Application by National Highways (the Applicant) for an Order granting Development Consent for the A46 Coventry Junctions (Walsgrave) (the Proposed Development)

Scoping Consultation

Our reference: PR23/0556
 Your reference: TR010066-000003

I write further to your letter dated 30th June 2023 in relation to the above scoping consultation. Rugby Borough Council (RBC) has considered the Environmental Scoping Report (HE604820-OIL-EGN-00-RP-LE-30002-P01) and requests that the following comments are taken into account by the Planning Inspectorate when adopting its Scoping Opinion.

Figure	Figure Name
2.3	Environmental Constraints

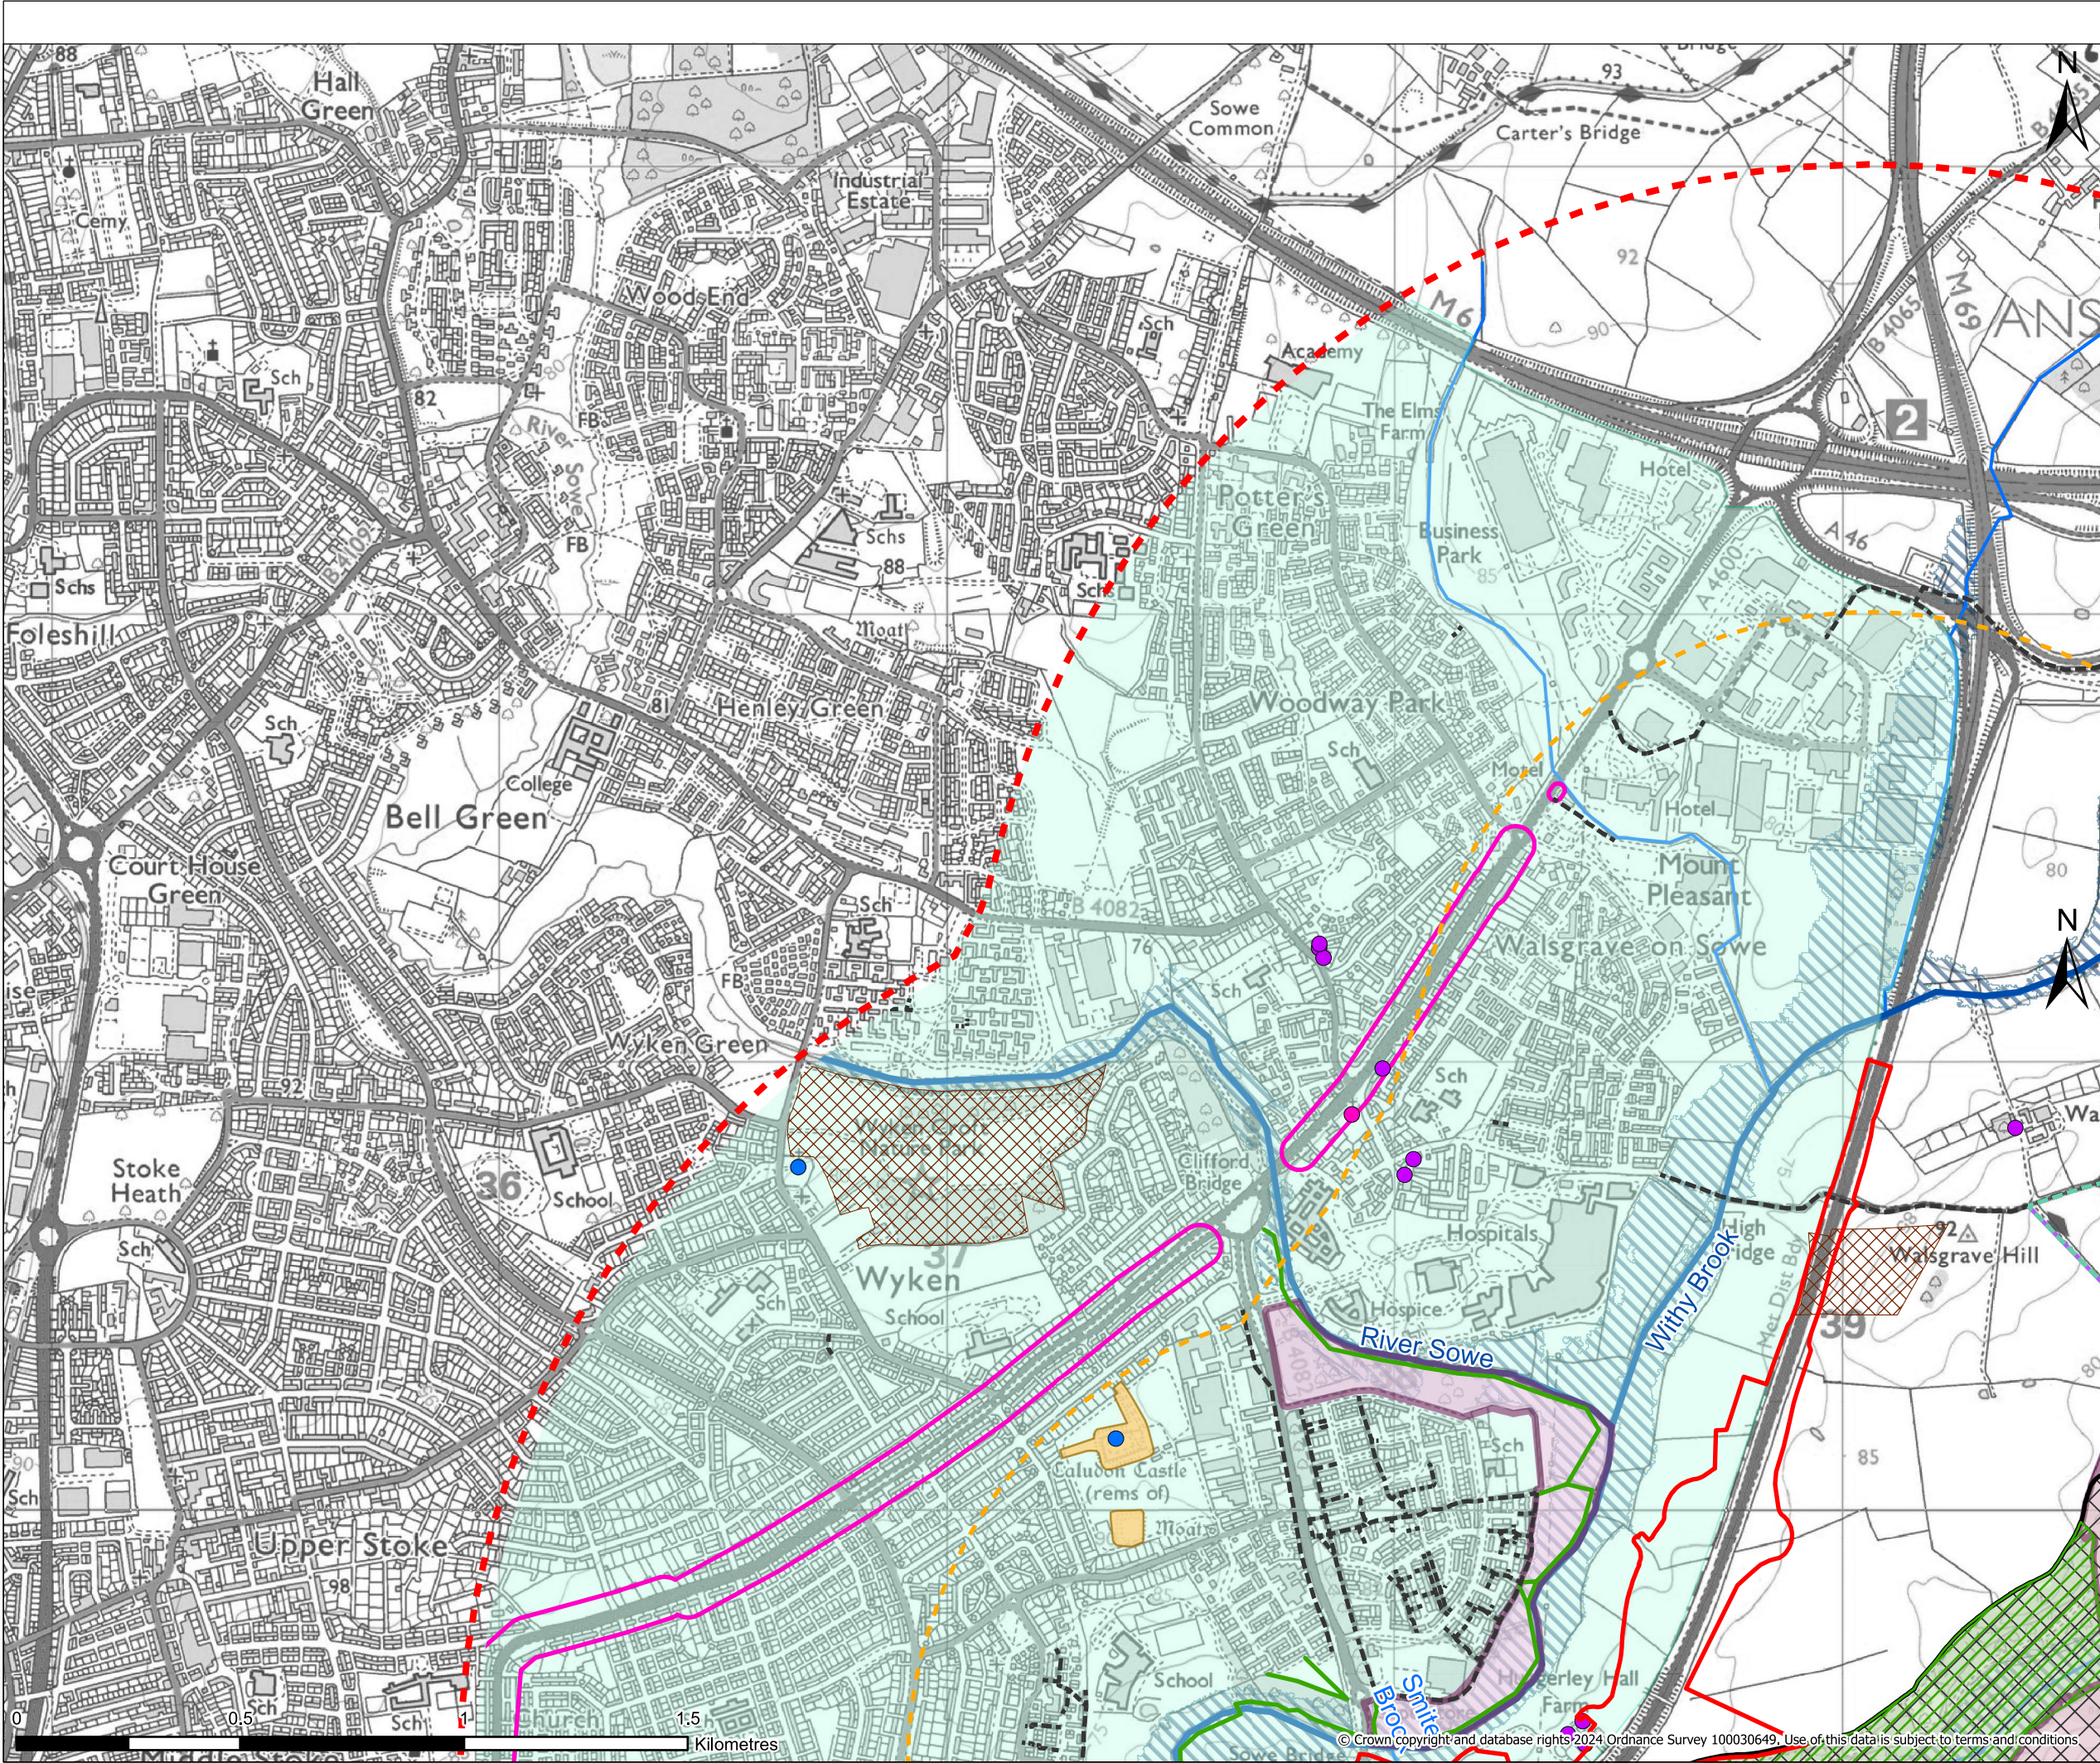
Section	Report	Comment
2.3.5.	Potentially sensitive receptors to the proposed scheme have been identified and are presented on the environmental constraints plan as shown in figure 2.3 in Appendix A and summarised as follows ...	The residential properties at Highfields and Combe Warren (accessed off Brinklow Road) should be included in this list given their proximity to the proposed development.
